Planning Officer: Zac Denton
Planning Application Ref: FP/76/18/T
Location: 1 Westmorland Drive, Felpham
Description of works: Fell 1No. English Oak
Reasons Given: Health and Safety Issues
Comments on Application:

Tree Officer / Parks and Greenspace Team

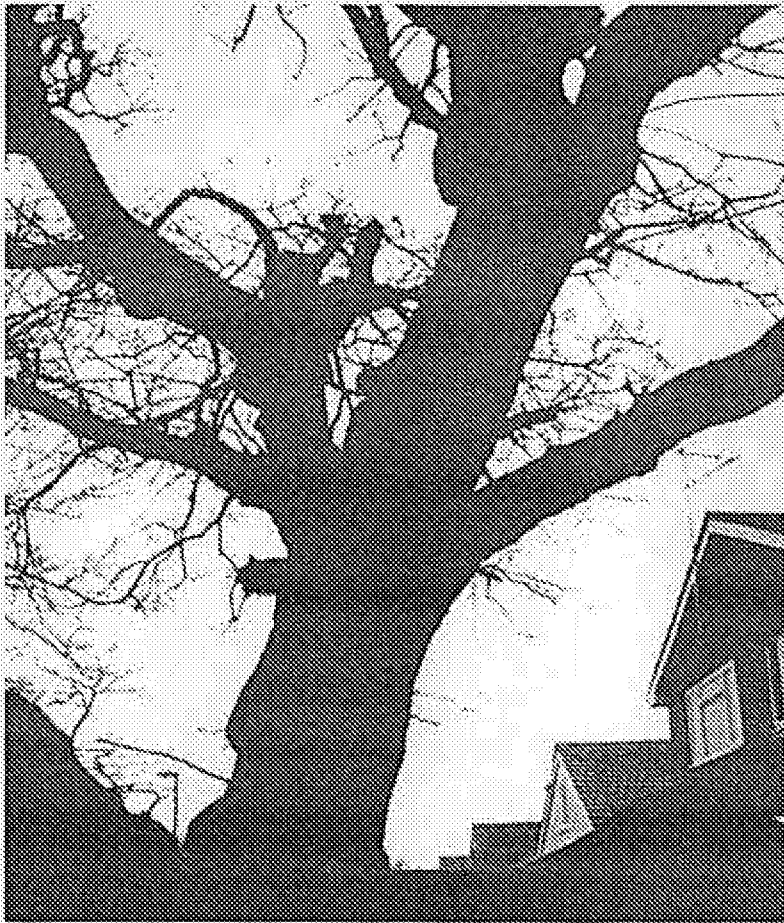
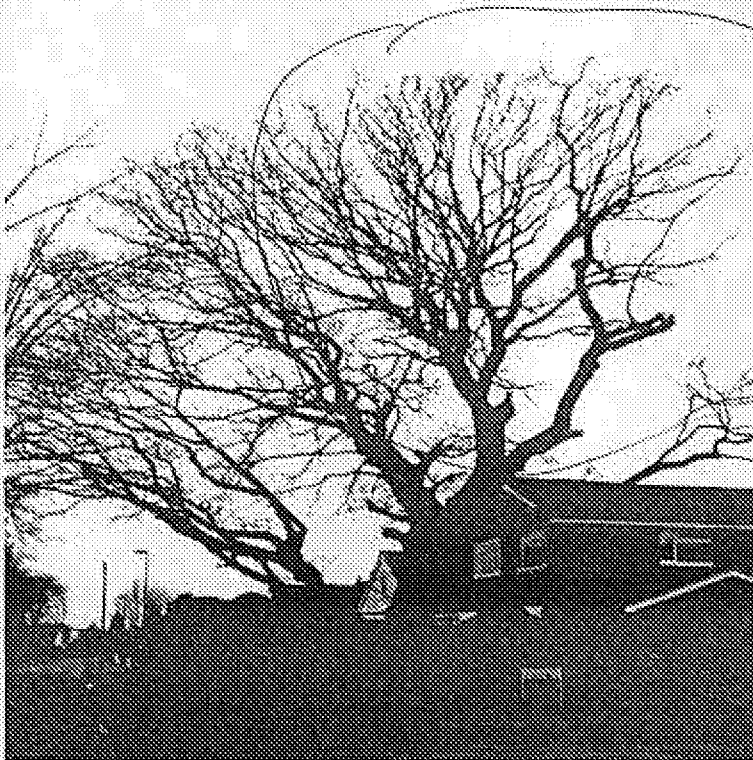
- This is a large spreading tree that has an imposing presence within the property and highly visible to the public at the junction of main residential roads.
- It is one of several mature oak and field maple locally that form part of a historic boundary line of trees.
- I saw no evidence of an obvious lighting strike (although cannot rule out the possibility) but share concern for the large areas of bark death and associated tarry exudate on the main stem. Although no obvious pathogen was apparent the symptoms are characteristic of Bulgaria canker infection and this could be explored as a possible cause of the crown dieback.
- There seems to be a close correlation between the region of bark death and crown dieback, suggesting xylem/phloem dysfunction. The remainder of the crown appears full and healthy, albeit with moderate shoot extension and crown density.

- While undoubtedly under some physiological distress, the precise cause of it has not been evidenced at this time and so stabilisation/recovery of vitality potentially remains an outcome.
- The immediate hazard presented by large items of deadwood in the crown should be addressed by the applicant as a matter of priority. Such work does not require consent from the Local Planning Authority.
- This is an important tree by virtue of its landscape value and assumed life expectancy. No evidence has been provided to suggest it does not remain viable for medium to long-term retention.
- There is no Arboricultural reason for the tree to be felled and its felling would detract from the amenities of the locality.

- I recommend **REFUSAL** for this application.
